November 24, 2020

**Re: Valle De Atrisco (PHASE, 1)
10001 Ceja Vista RD
30-Day Temporary Certificate of Occupancy
Transportation Development Final Inspection
Engineer's/Architect's Stamp dated 10-2-17 (P09D002D)
Certification dated 11-20-20**

## A1 TRAFFIC CIRCULATION LAYOUT

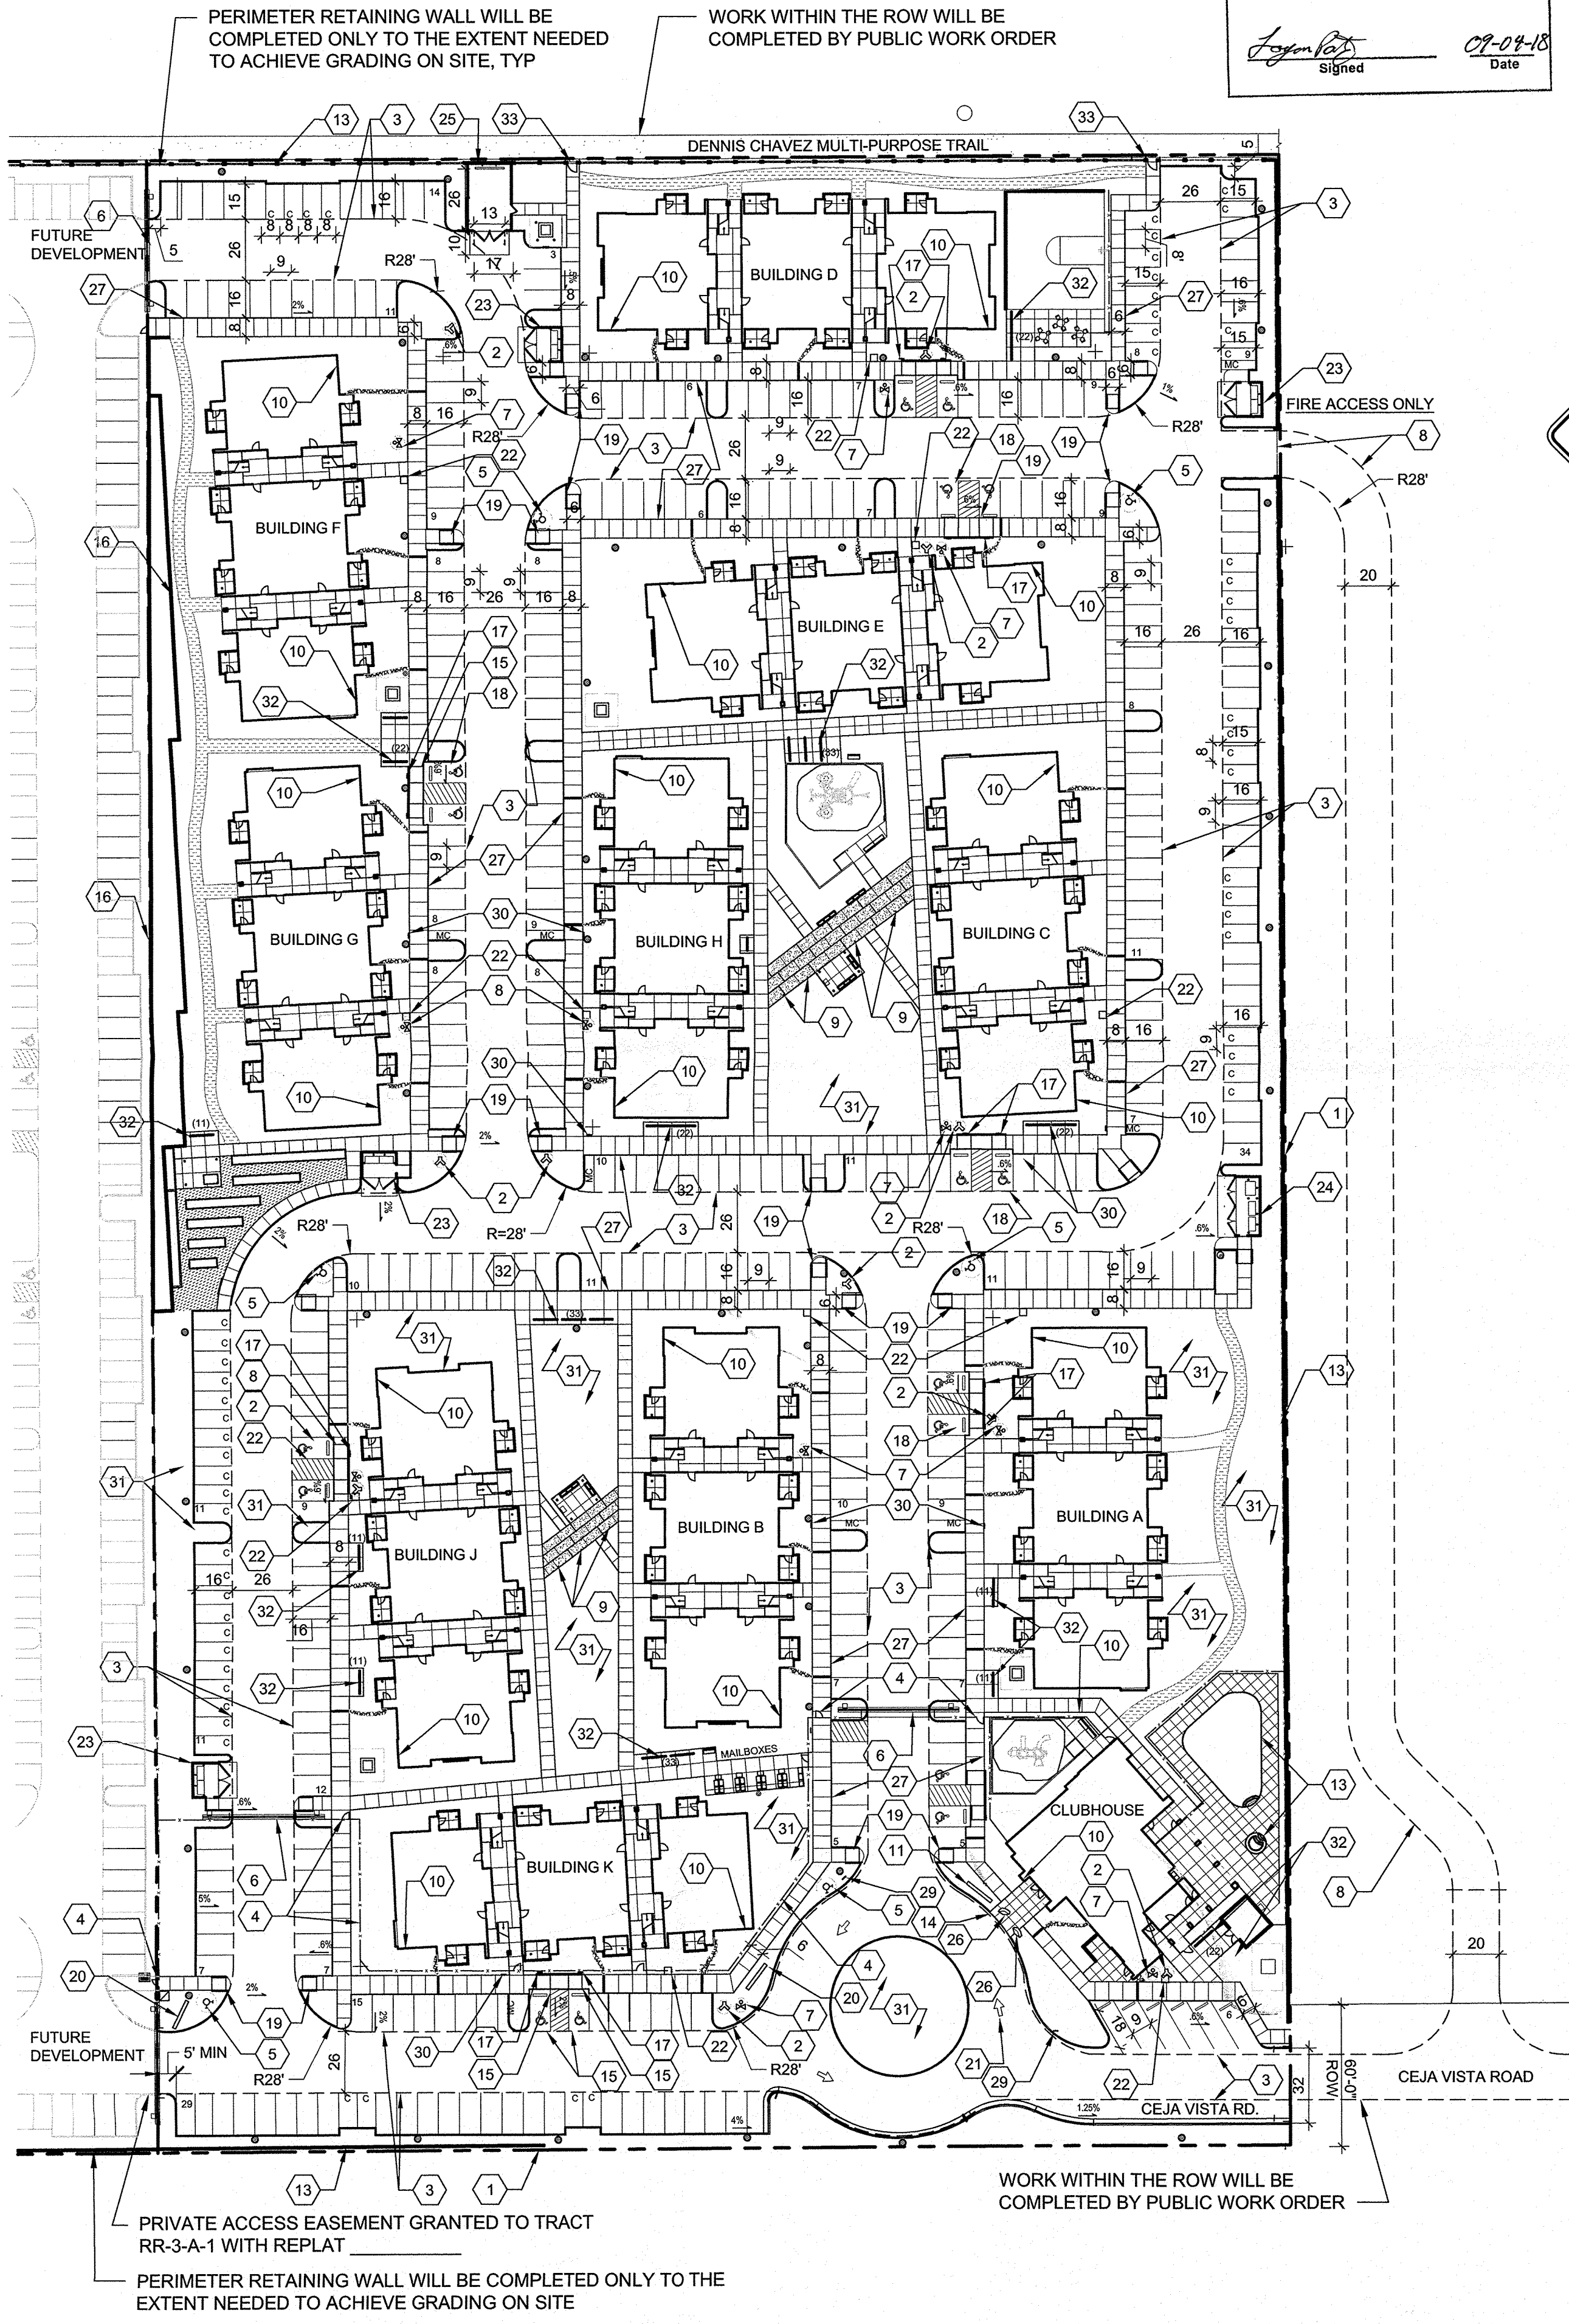
- Please complete asphalt markings for all COMPACT stall spaces
- Add missing Motorcycle parking & signage. Complete asphalt patch paving
- Remove construction equipment, debris and Porta potties at Phase 1 location.
- Completion of punch items listed on Certification Letter for Phase 2 certification.

1. The approved and stamped TCL with changes drawn in red.
2. Transportation Certification letter on either the plan or applicants letterhead.
3. A Drainage Transportation Information Sheet (DTIS)
4. Send an electronic copy of your submittal to PLNDRS@cabq.gov.
5. The \$75 re-submittal fee for log in and evaluation by Transportation.
